DRB Application No.: 05DRB-01147 (SBP)	Project # 1004326
Project Name: LOOP INDUSTRIAL DIST. UNIT 5	
Agent: Insite Works	Phone No.: 858-0100

**CITY OF ALBUQUERQUE
PLANNING DEPARTMENT
July 20, 2005
DRB Comments**

RE: Lot 14-A—2-A, Loop Industrial District, Unit 5/spbp

Sheet Title | BUILDING ELEVATIONS  
Sheet Number |  
**A2.0DRB**

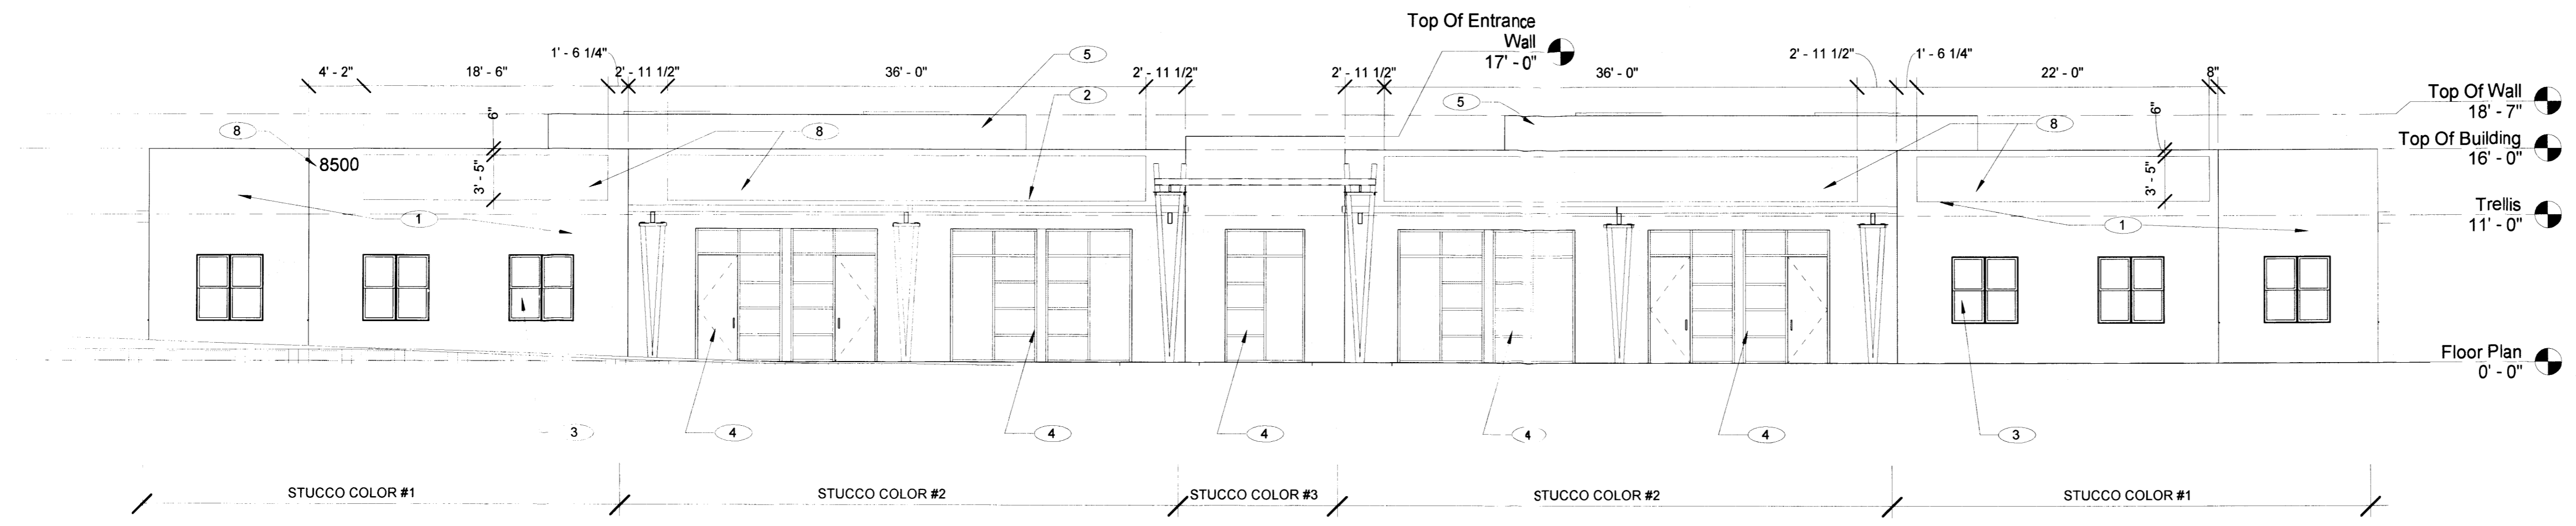
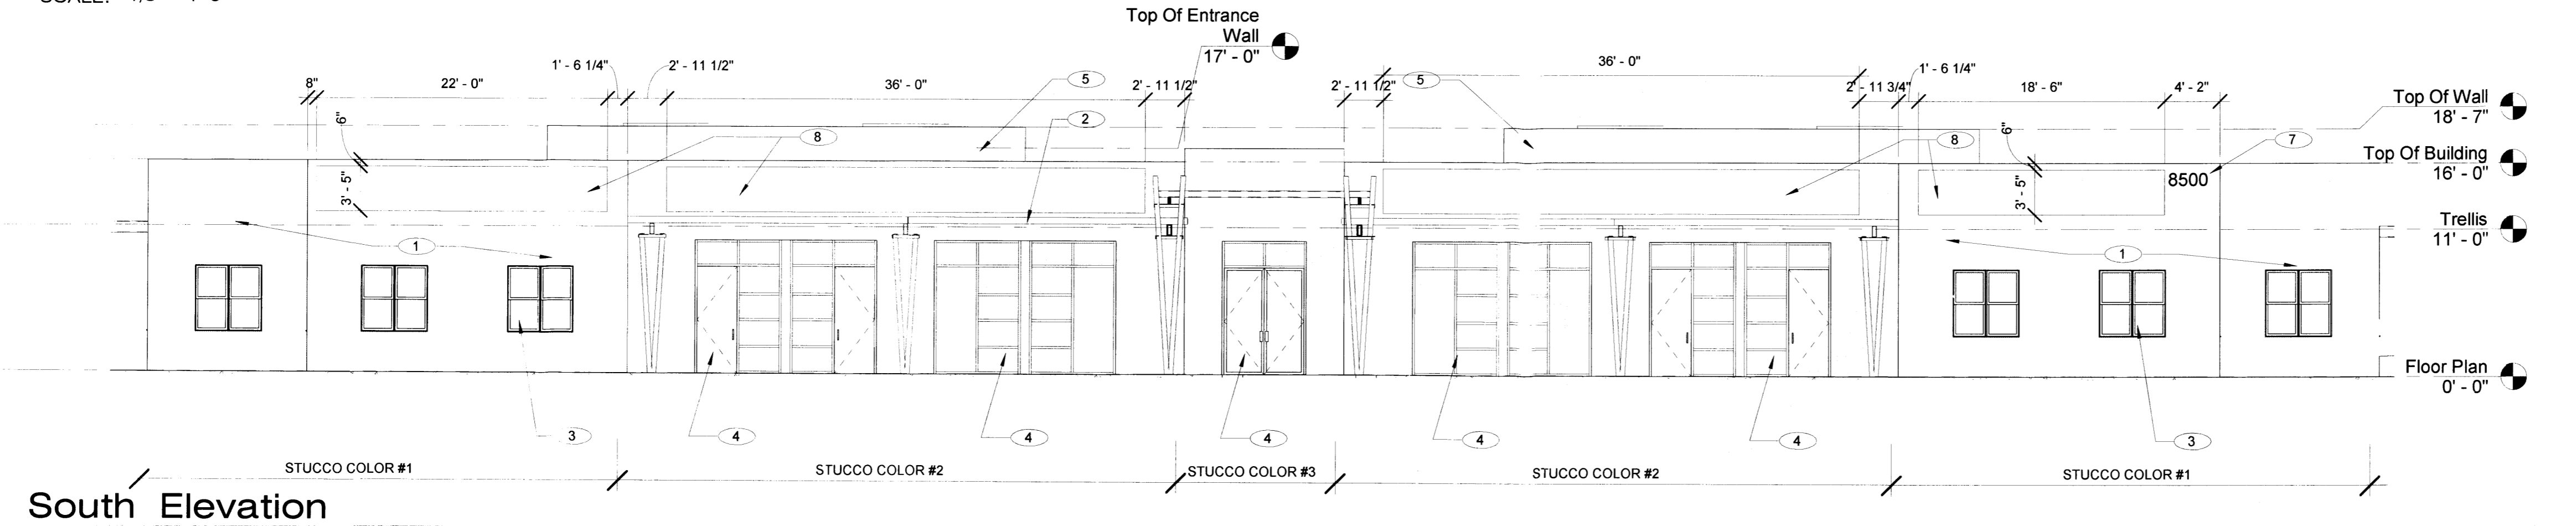
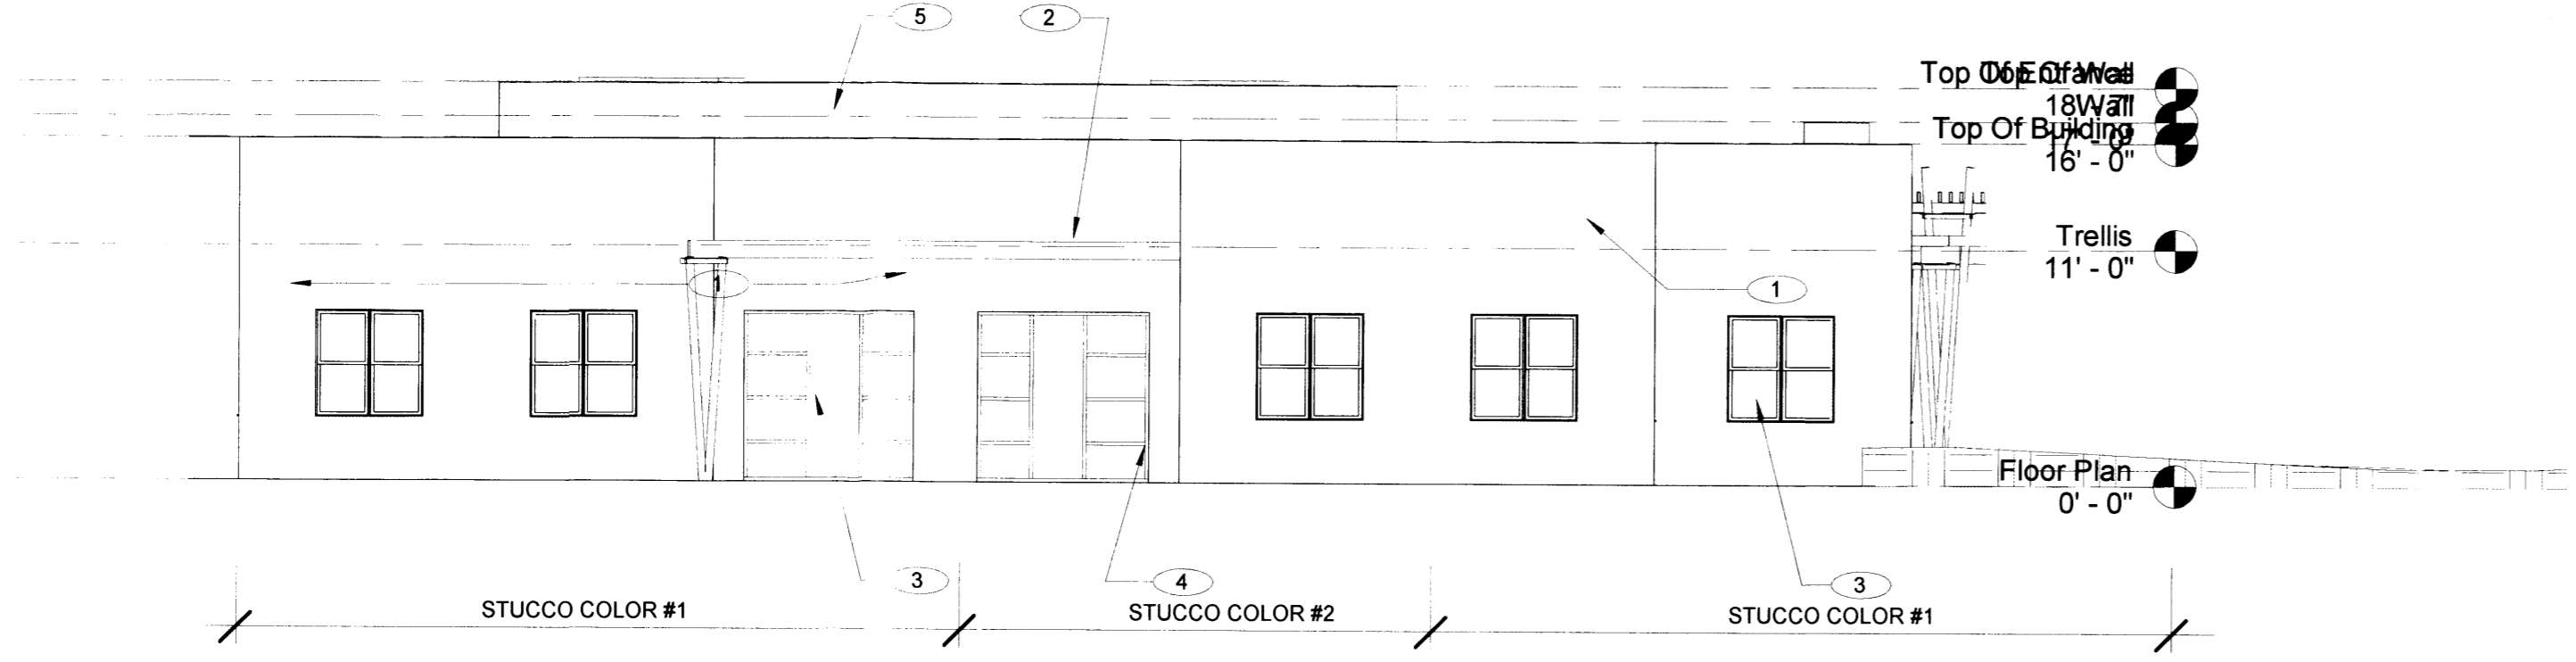
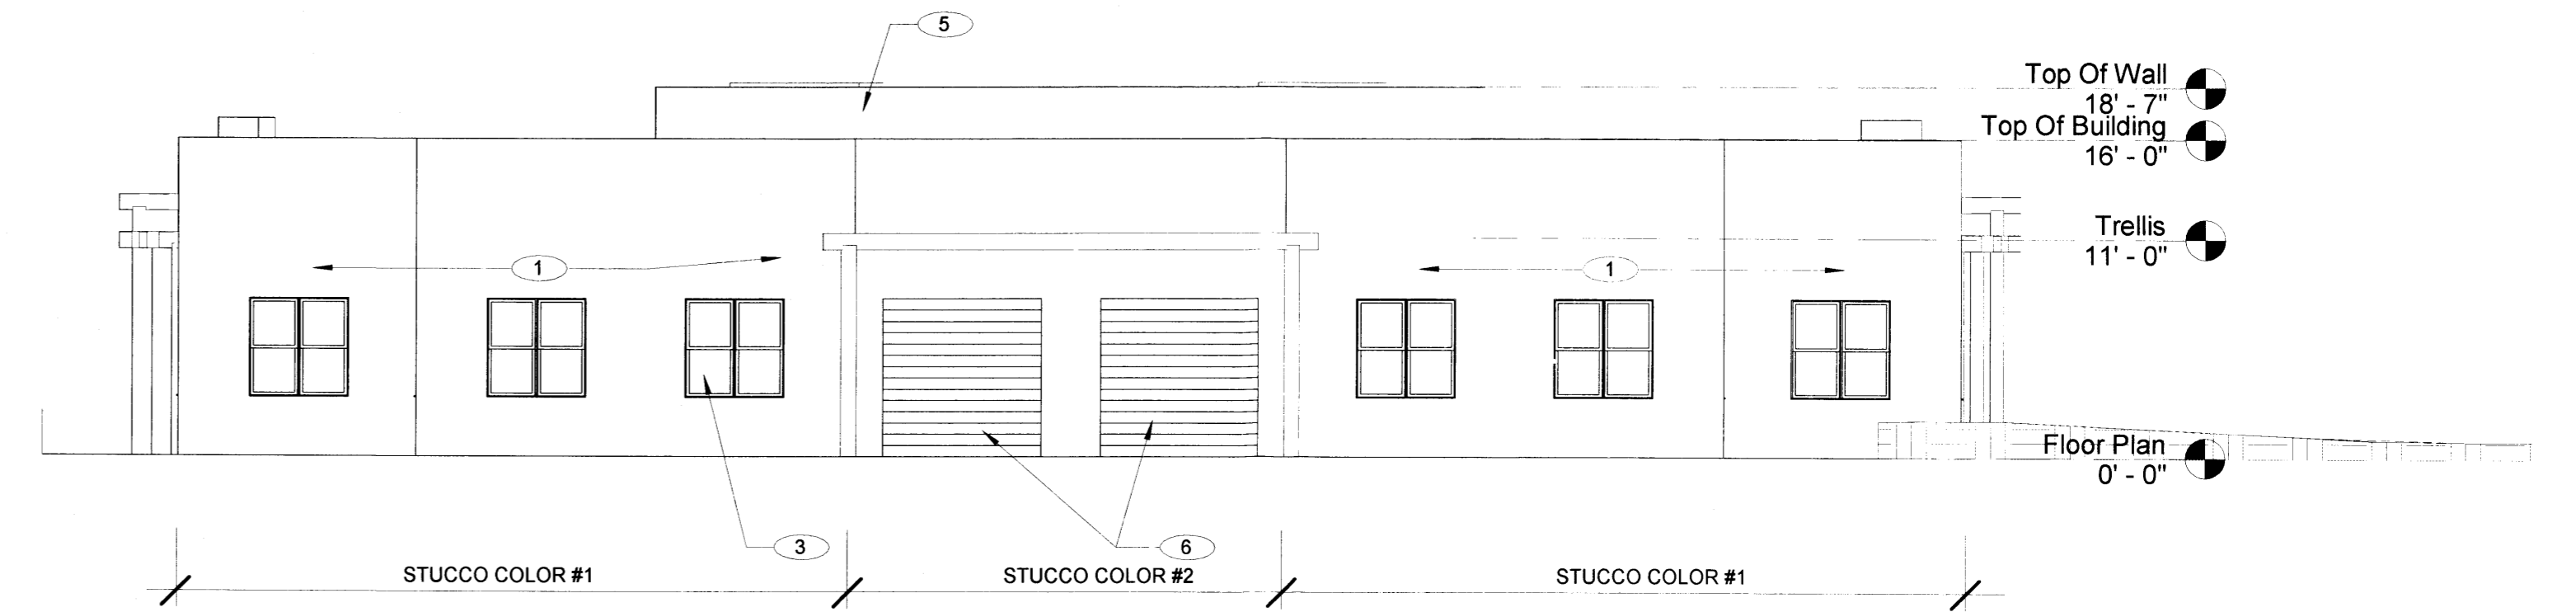
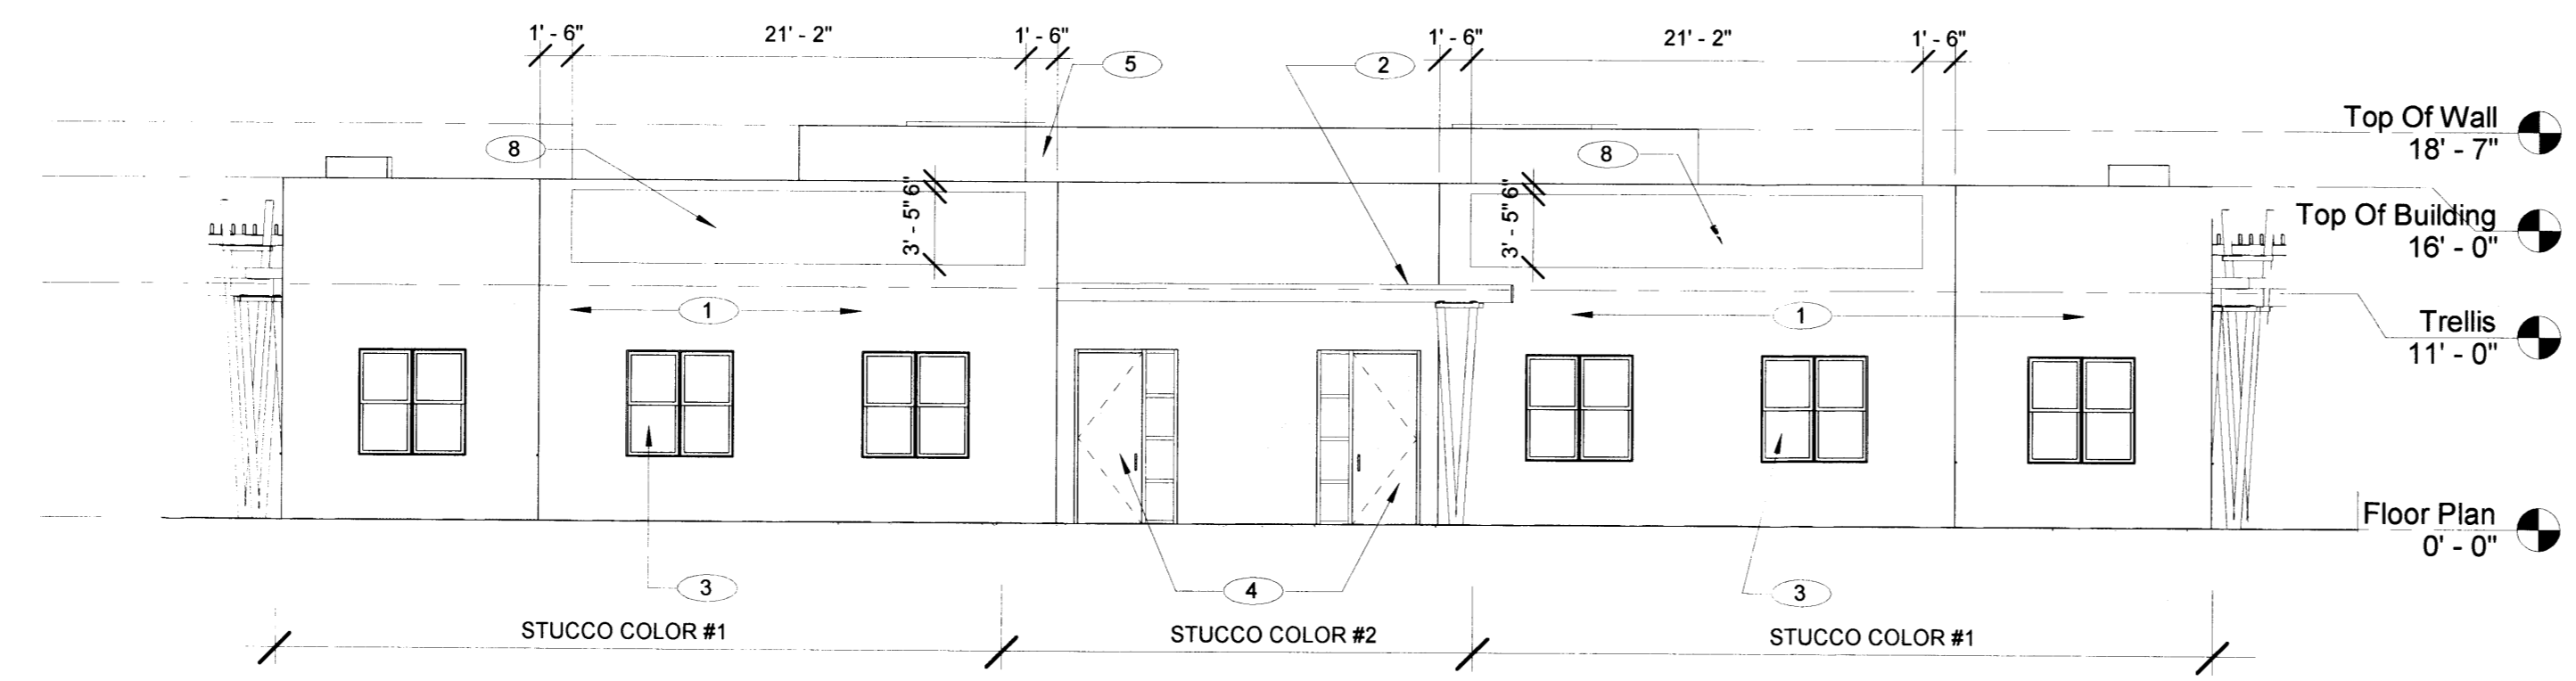
The building mounted signs can not exceed 15% for the north, south & east elevations or 20% of the total west elevation following Zone Code IP requirements. The length of each elevation is missing.
